East Anglia ONE North and East Anglia TWO Offshore Windfarms

Applicants' Comments on Marlesford Parish Council's Deadline 8 Submissions

Applicant: East Anglia TWO and East Anglia ONE North Limited
Document Reference: ExA.AS-14.D9.V1
SPR Reference: EA1N_EA2-DWF-ENV-REP-IBR-001043

Date: 15th April 2021
Revision: Version 1
Author: Royal HaskoningDHV

MARLESFORD MITIGATION SCHEME (A12)
PRELIMINARY DESIGN
(SHEET 1 OF 2)

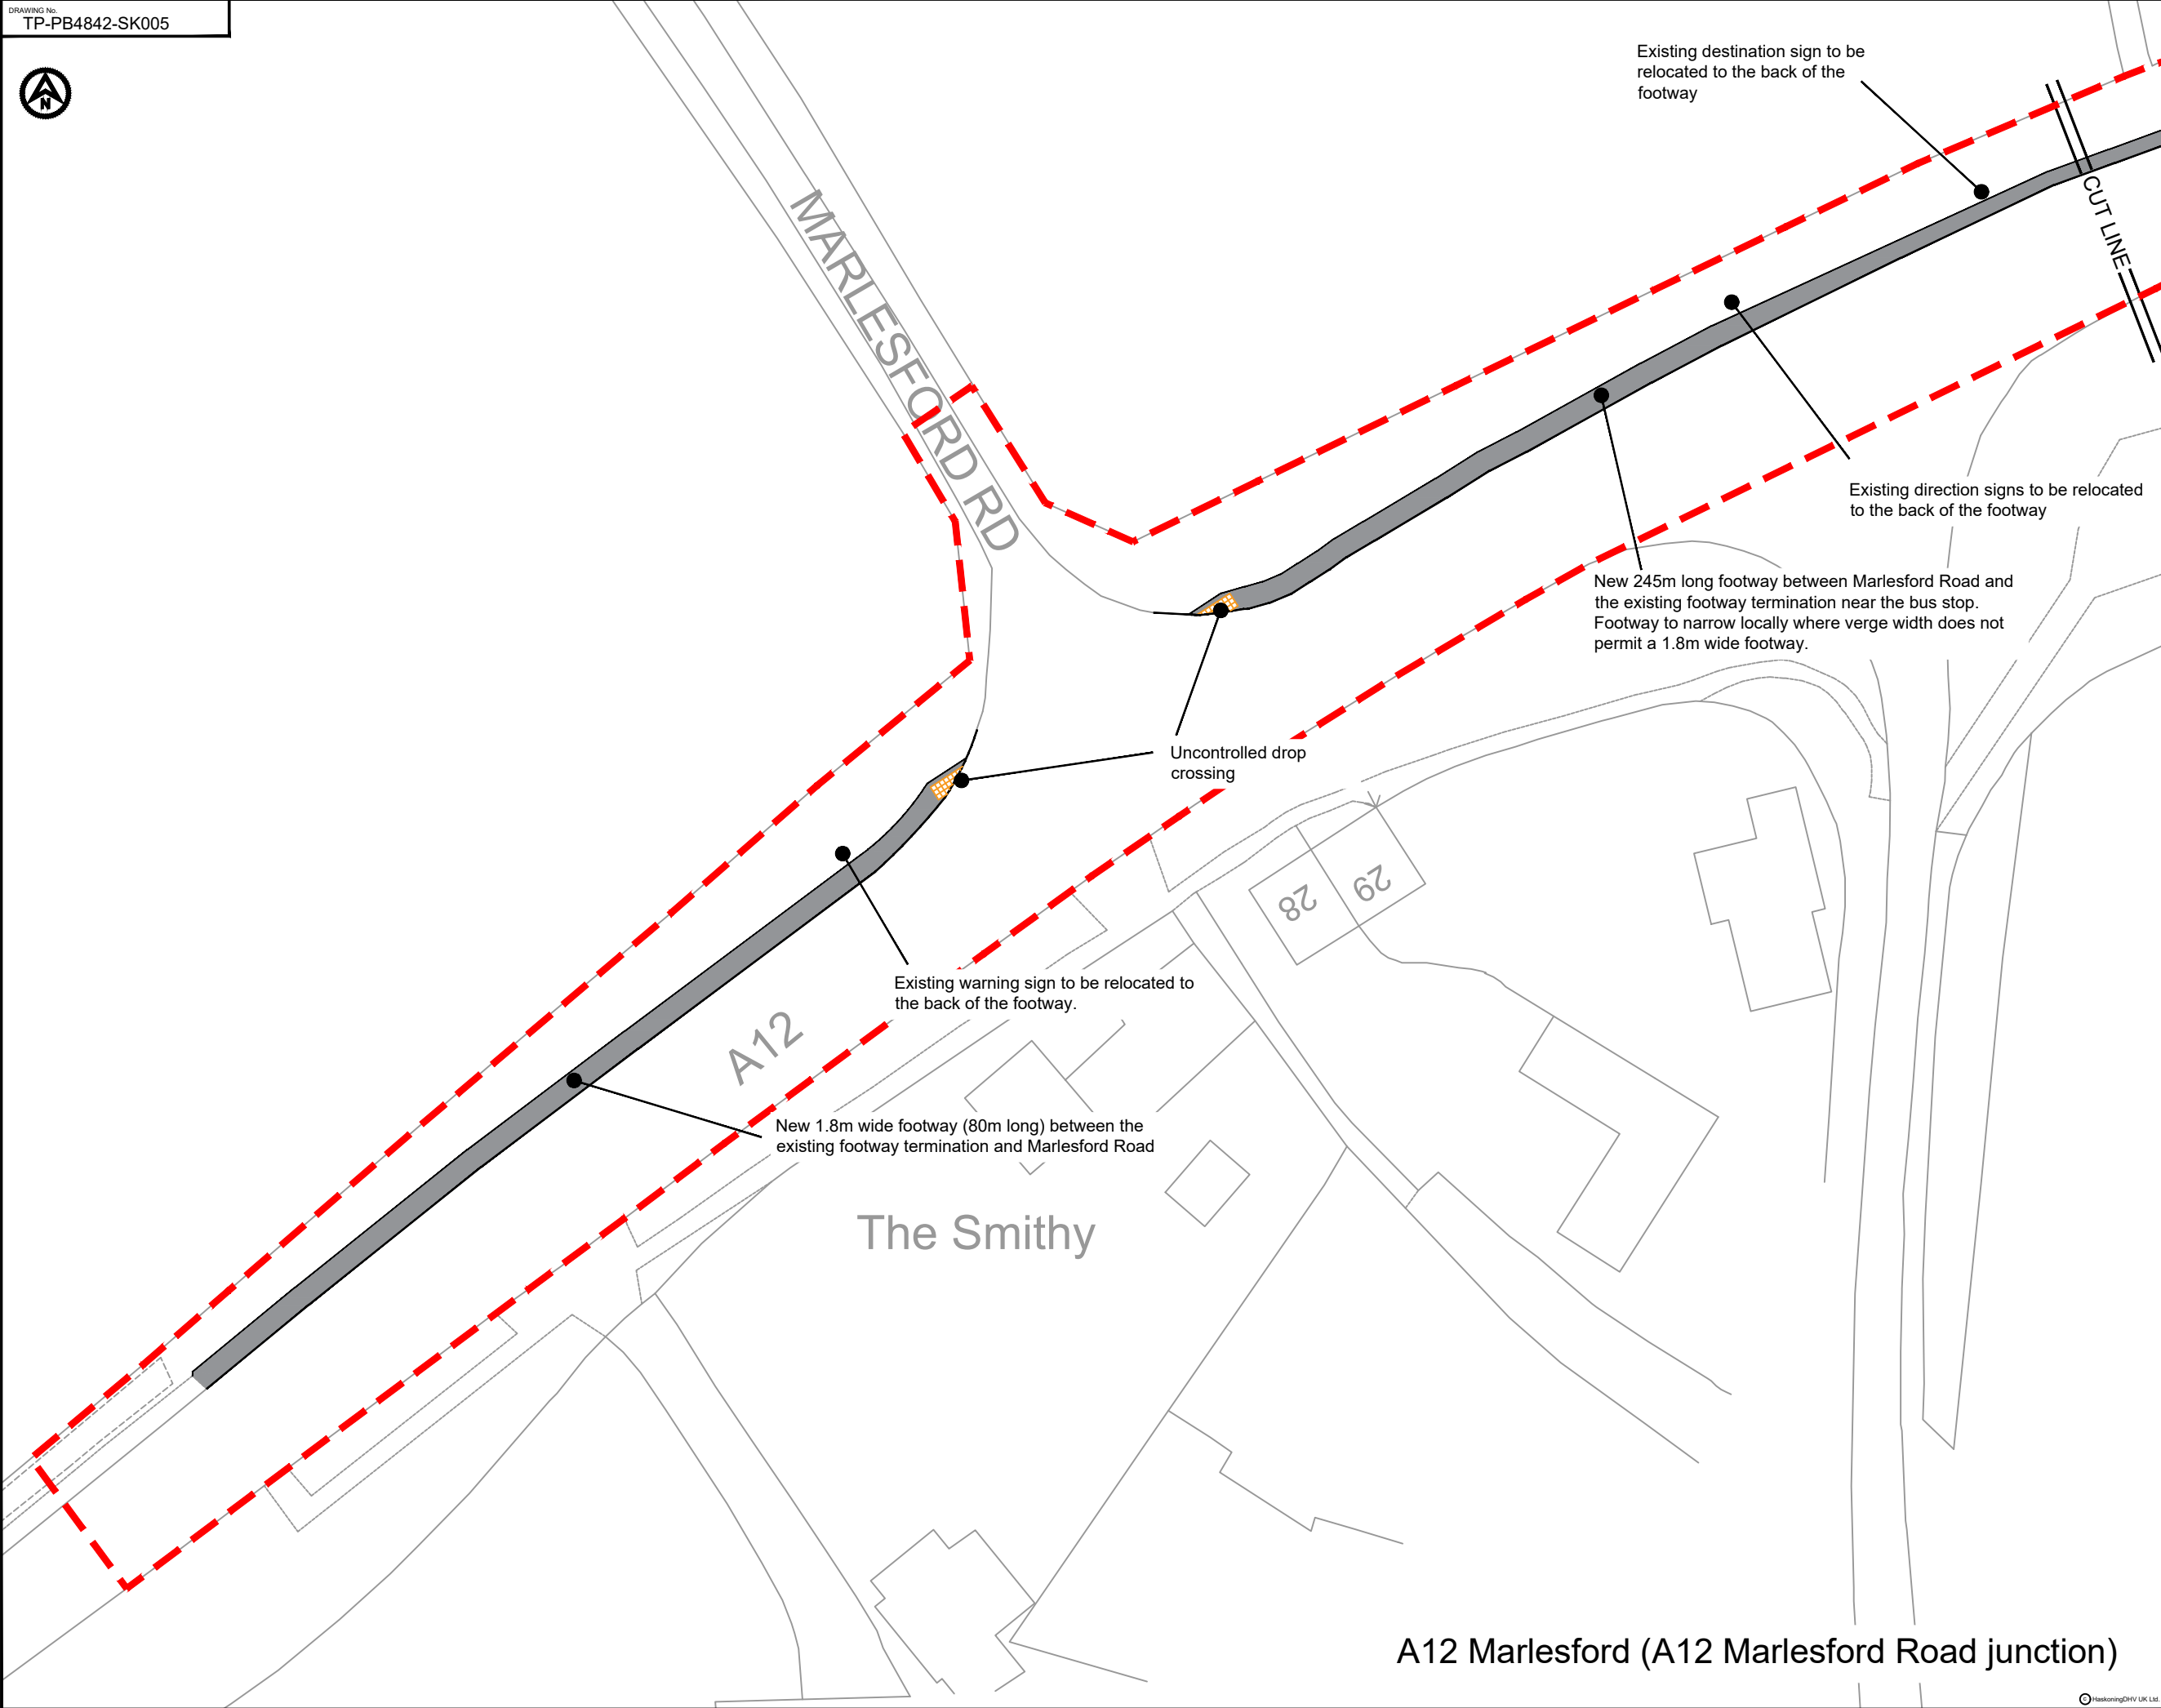
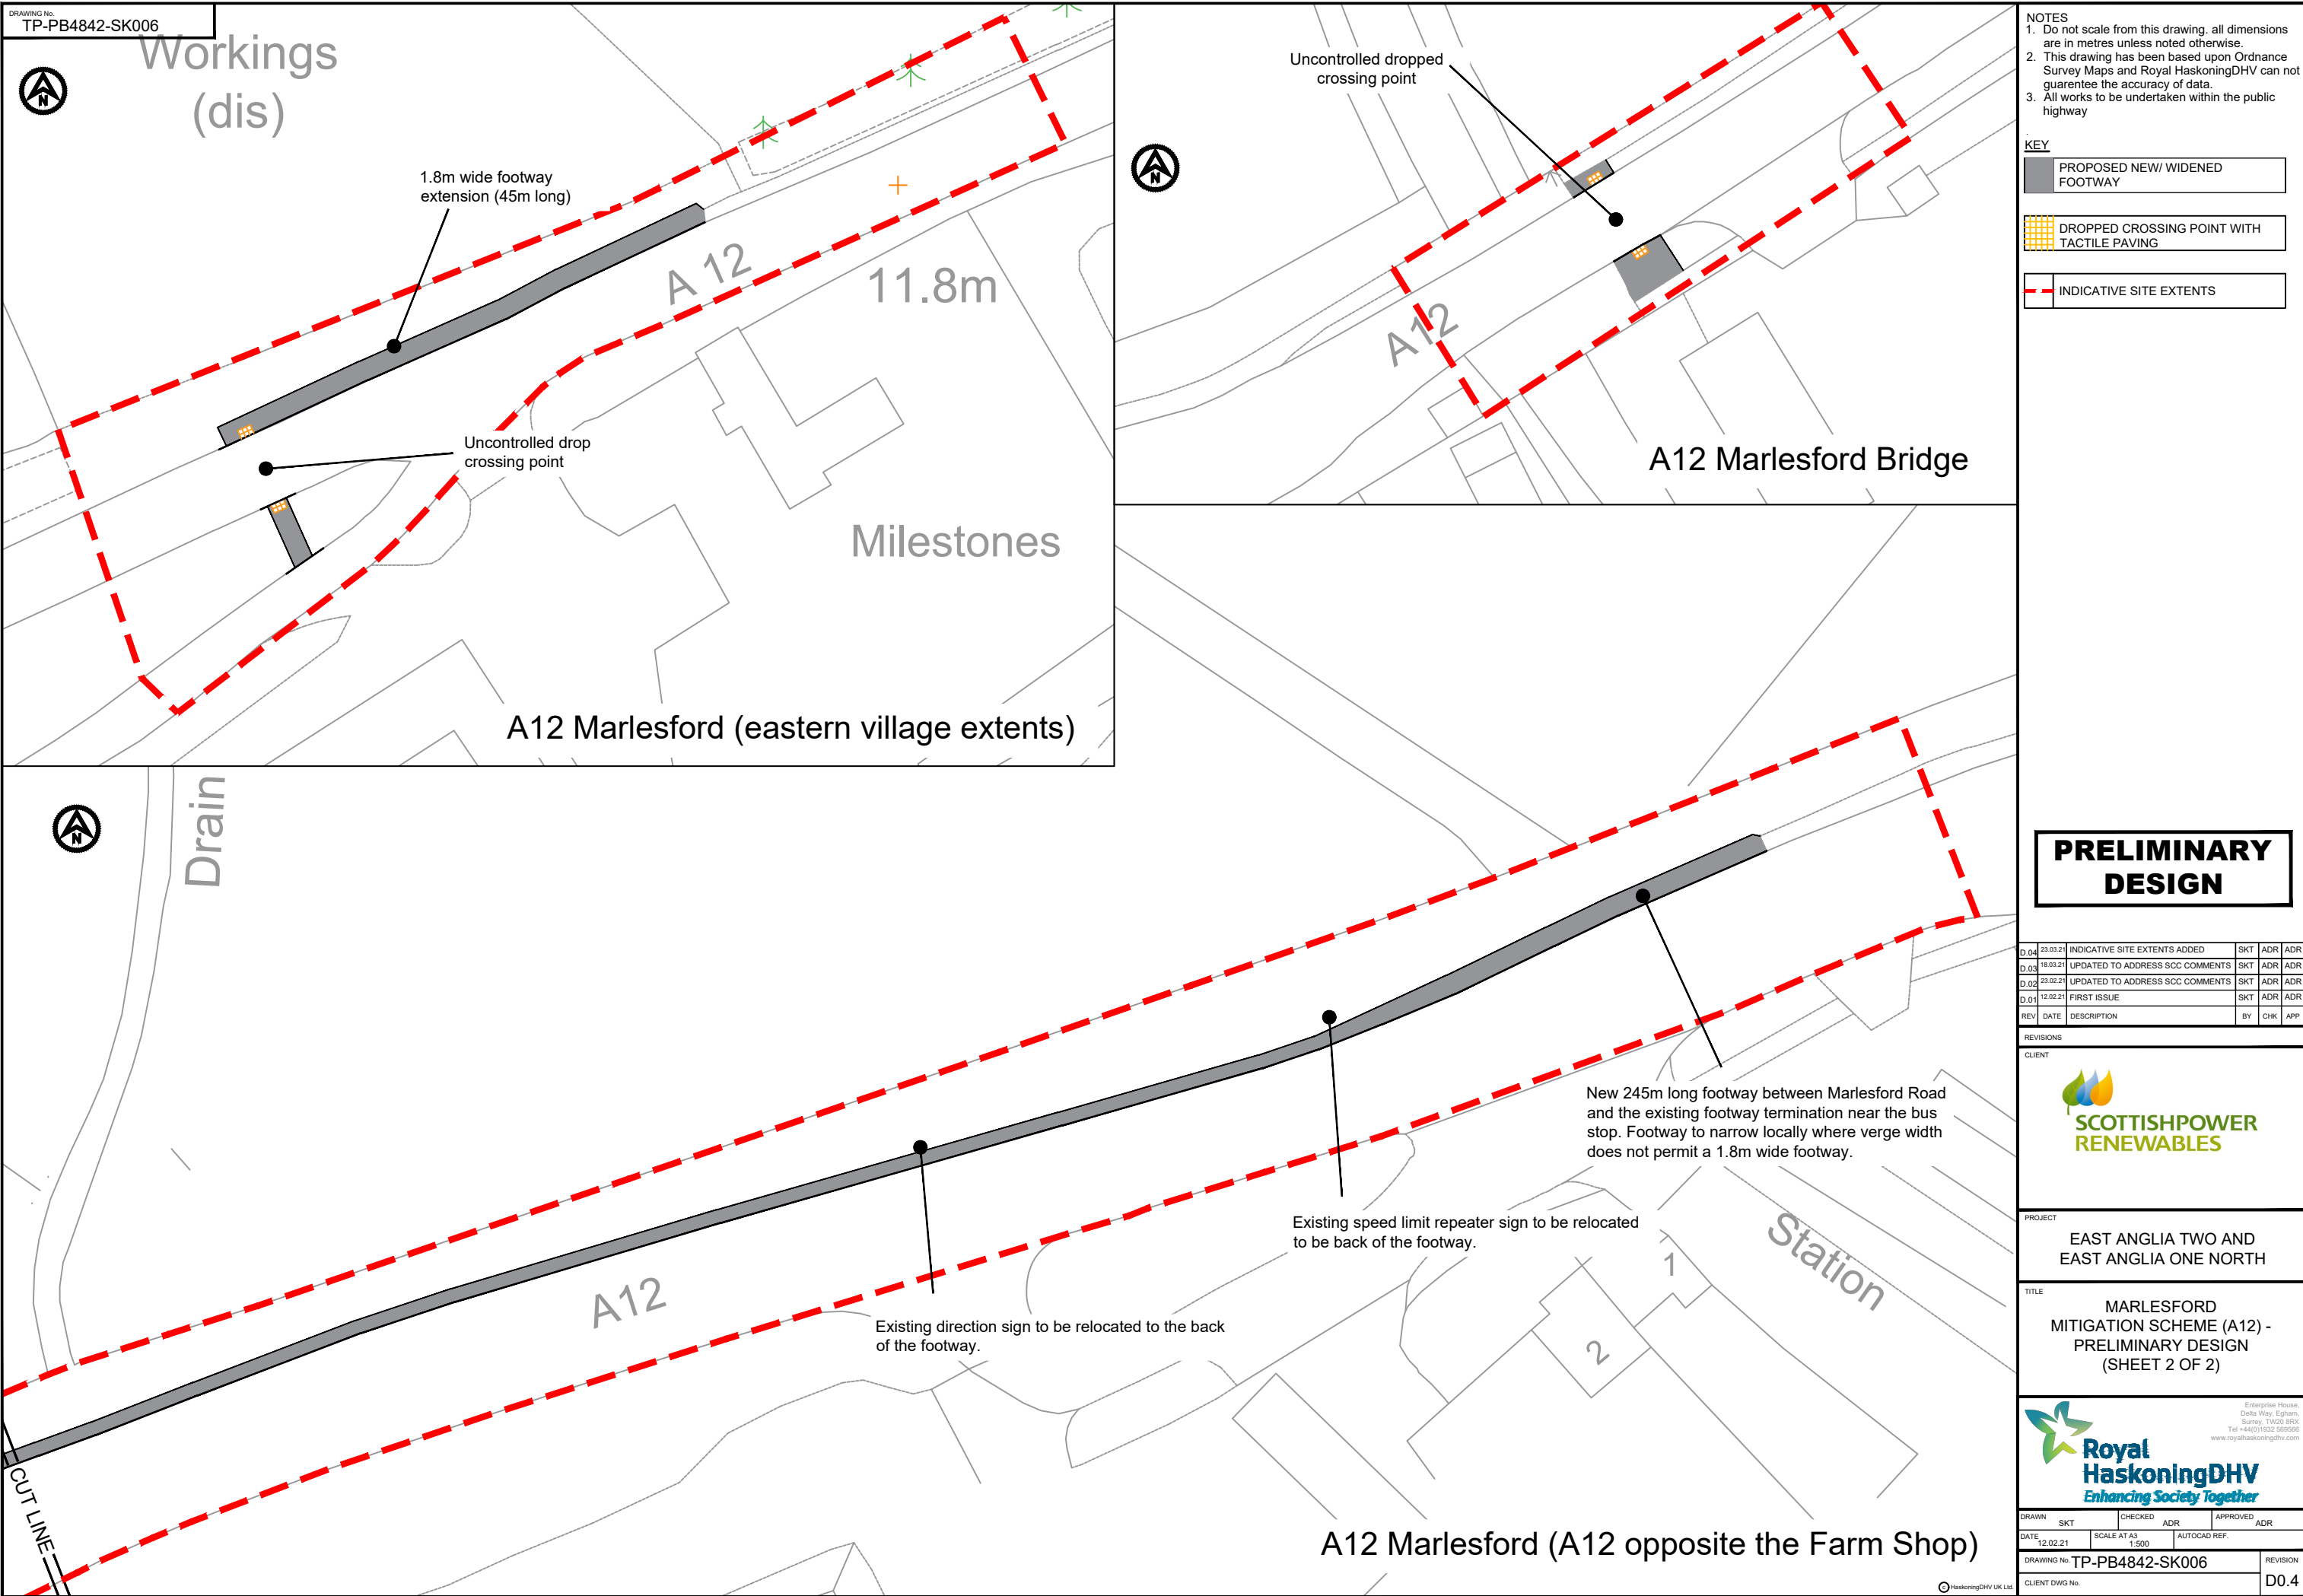
4	<p>Community severance is already an issue in Marlesford and Little Glemham with fear and intimidation from current traffic levels being</p>	<p>The Outline CTMP submitted at Deadline 8 (REP8-021), includes the commitment to mitigation measures at Marlesford, known as the Marlesford</p>

ID	Marlesford Parish Council Comment	Applicants' Comments
	<p>a real concern. We echo the ExA view that Marlesford is “the first unimproved section of the A12 after the dual carriageway section [north of Wickham Market]”. We would ask the Applicant to continue its work with Suffolk County Council to ensure the provision of appropriate and proportional mitigation within the village of Marlesford. The Parish Council believe that both stretches of proposed foot path should be on the north side of the A12. Mitigation should take place before construction works begin on the Friston site.</p>	<p>Mitigation Scheme. This scheme has been developed in consultation with SCC and in response to the Parish Councils comments and as such, includes the provision of sections of footway along the northern side of the A12, as preferred by Marlesford Parish Council.</p> <p>As specified within the Outline CTMP (REP8-021) the Marlesford Mitigation Scheme will be in place prior to the commencement of Work Nos. 6, 8, 9, 11, 12, 13, 16 to 23, 26, 30, 31, 32, 34, 38 to 43 (with the exception of the creation of highway accesses).</p>

5	<p>We argue that Marlesford and Little Glemham will both be severely impacted if construction of Sizewell C and EA1N and EA2 go ahead at the same time. We accept that neither consideration of EDF's proposed Two Village Bypass, nor our preferred Four Village Bypass form a part of the Applicants' DCO application, but we strongly argue here (and will do so in the Examination of EDF's plans for Sizewell C) that traffic on the unimproved stretch of the A12 through Marlesford and Little Glemham is already at a level where it causes fear and intimidation. With a likely 115% increase in HGV daily movement at the Sizewell peak, it is unlikely that mitigation alone could address the adverse impacts. The bypassing of Marlesford and Little Glemham has been on the table since its route was approved in 1995 and most recently a Four Village Bypass was promoted by Suffolk County Council as SEGway (the Suffolk Energy Gateway), but desperately needed funding has not been forthcoming and Marlesford and Little Glemham residents seem destined to have to suffer an intolerable increase in traffic along with its associated noise, air quality and vibration impacts. An additional consideration is that the current design of the Two Village Bypass is likely to preclude a “retro-fit” of a Marlesford and Little</p>	<p>The Applicants note that the comments in relation to the Two and Four Village bypass is directed more towards the Sizewell C DCO application submitted by EDF, given that the Sizewell C project is seeking rights to construct the new proposed Two Village Bypass to offset the impacts of the Sizewell C project.</p> <p>The Applicants have undertaken an assessment of the potential cumulative impacts with Sizewell C (REP6-043). This assessment identifies that should there be an overlap of the construction programmes for both the Projects and Sizewell C, that there could be potentially significant amenity impacts along the A12 through Marlesford and Little Glemham.</p> <p>The Applicants have therefore committed to the provision of appropriate and proportional mitigation through the development of the Marlesford Mitigation Scheme. The Applicants do not consider a Two or Four Village bypass necessary to effectively mitigate the Projects impacts – either alone or cumulatively – and note that the proposed bypass is mitigation proposed by the Sizewell C project to offset its impacts alone.</p> <p>The Outline CTMP submitted at Deadline 8 (REP8-021), includes the commitment to and detail of the mitigation measures at Marlesford to provide better pedestrian connectivity with Little Glemham (known as the Marlesford Mitigation Scheme). The Applicants note that in order to provide certainty to</p>
